A1 Birtley to Coal House

Scheme Number: TR010031

Statement of Common Ground with Gateshead Council

STATEMENT OF COMMON GROUND WITH GATESHEAD COUNCIL

DRAFT

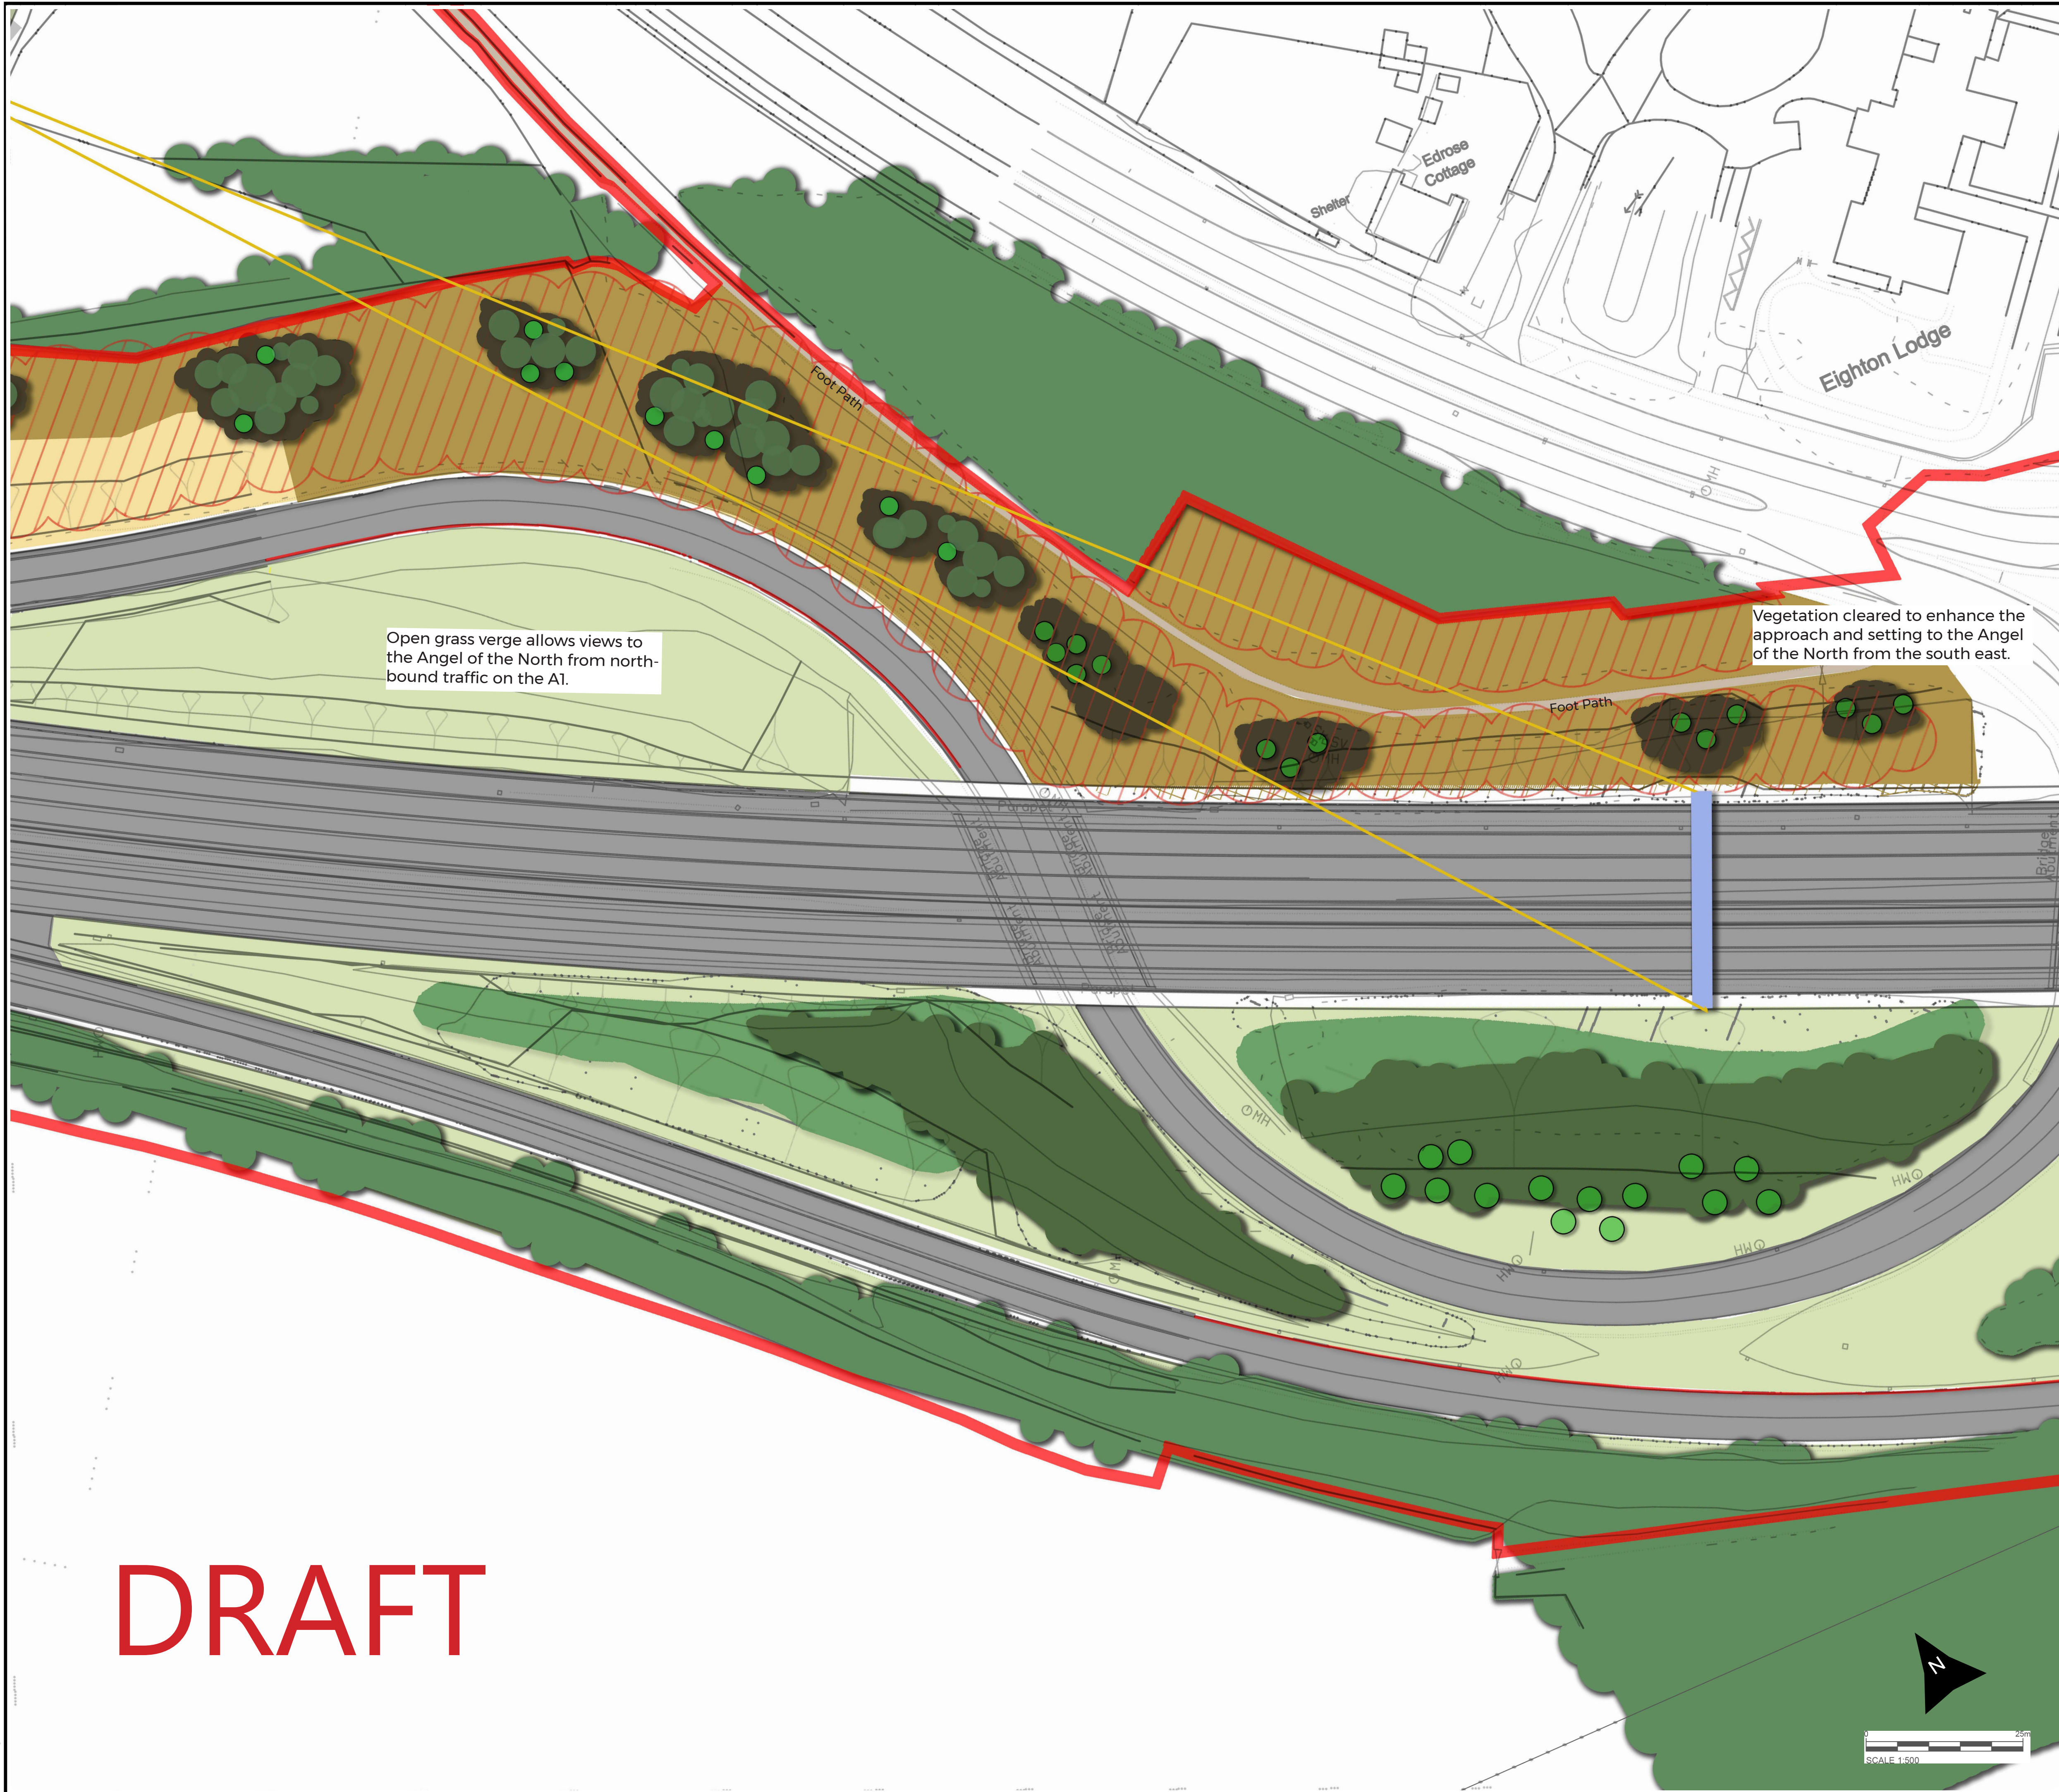
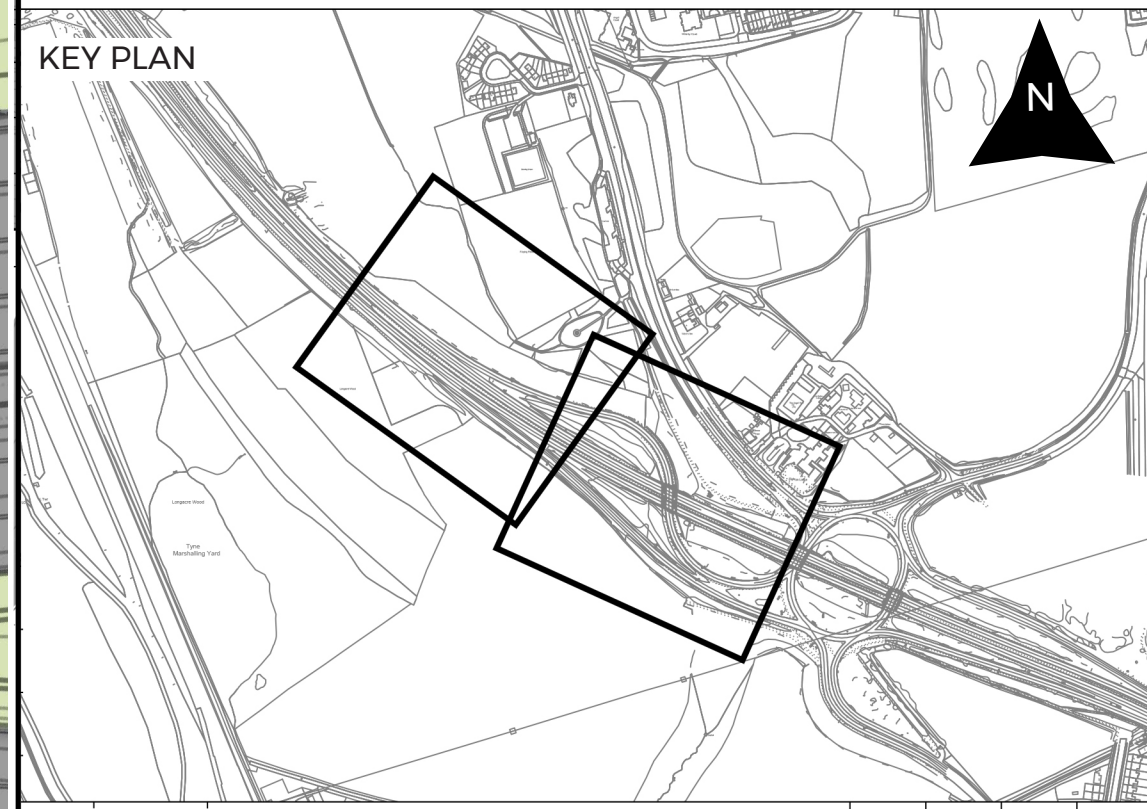
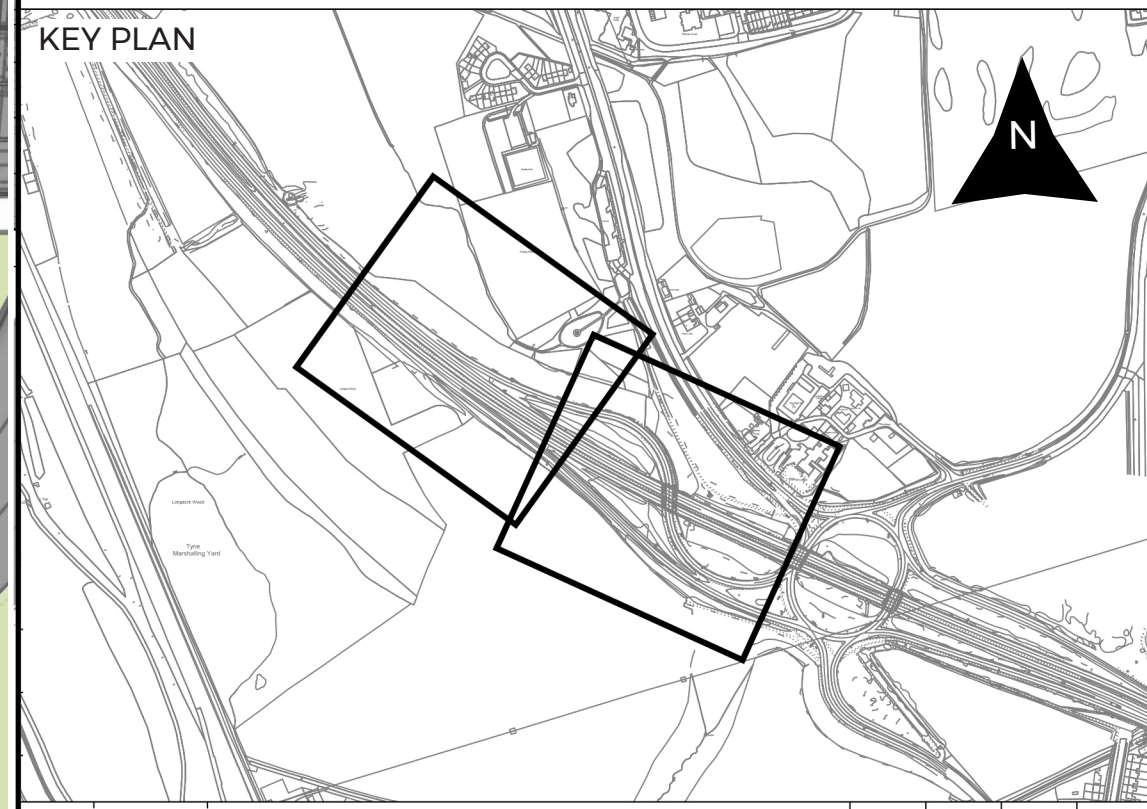
Section	Sub-section	Gateshead Council Position	Highways England Position	Status
Environmental Statement - Chapter 6: Cultural Heritage	6.8 Potential impacts	At a meeting on Thursday 4 June 2020, Gateshead Council advised that they find the revised landscape mitigation plan around the Angel of the North [REP5-005] broadly acceptable, but are still reviewing the drawing with the intention of providing feedback to Highways England. On point of clarification the are currently in the process of reviewing and providing comments on the updated landscape mitigation plan in consultation with the artist Anthony Gormley.	A revised landscape mitigation plan [REP5-005] has been submitted to Gateshead Council The updated drawing takes into account Gateshead Council's request in 8 March 2020 to review the trees at along the A1, whilst acknowledging that a substantial number of trees will need to be maintained for ecological reasons.	Under Discussion

Gateshead Council recognises tensions between artist, climate change and ecology views. Gateshead Council requested visuals of the proposed A1 works showing the landscape in its finished (post construction) massing would assist in developing the detailed landscape design and enable views to be managed alongside gantries and other infrastructure.	Following a meeting on 9 April 2020 between Gateshead Council Landscape and Ecology Officers and Highways England environmental specialists there is an agreement in principle to the design of the landscape and habitat mitigation proposals within the Order Limits and associated with the interface of the Scheme and the Angel of the North. An updated version of The Landscape	Under Discussion

Section	Sub-section	Gateshead Council Position	Highways England Position	Status
		Agreed in November 2019 that a single joint landscaping scheme should be developed by Highways England and Gateshead Council. Discussions are ongoing.	Mitigation Design, Figure 7.6 of the ES [APP-061] showing landscape and habitat mitigation planting around the Angel of the North will be produced. It is understood that agreement to this plan will be subject to further discussions internally within Gateshead Council and consideration of the effects on the impact assessment	
		Prior to the submission of the updated Landscape Mitigation Plan [REP5-005], the Council did not agree that there will permanent beneficial impacts on the setting of the Angel as a result of reduced planting, and the effect of the gantries will be significant. Gateshead Council has advised that their concerns on this matter have been reduced, but will advise on specific details following Deadline 8.	Views from the road towards the Angel of the North would be slightly more restricted due to the installation of gantries but the effect would not be significant. Appendix 2.0 B Gantry Report [EX/D4/015] of the Applicant's Response to the ExA's Second Written Questions addresses the effect that these gantries will have on views of the Angel of the North and confirms that the effect of the installation of the gantries on the Angel of the North would not be significant.	Under Discussion
